KITTITAS COUNTY COMMUNITY DEVELOPMENT SERVICES

December 12, 2019

RE: Cle Elum Storage Conditional Use Application (CU-19-00004)

CLE ELUM SELF STORAGE
 MATT WATSON
SITE PLAN

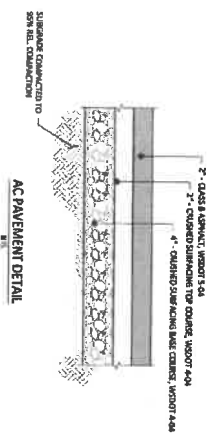
- a. Revised site plan depicting :
 - The orientation of the storage buildings, specifically the face of each storage structure.
- b. Revised narrative and site plan depicting:
 - Plans for aesthetic improvements and/or sight screening pursuant to KCC17.15.060.1 footnote #14
- c. Revised SEPA checklist
 - More information is needed in section's A-11, B-10, B-14(f), and B-1(e). Answers must address every element of the question with as much specificity as possible.
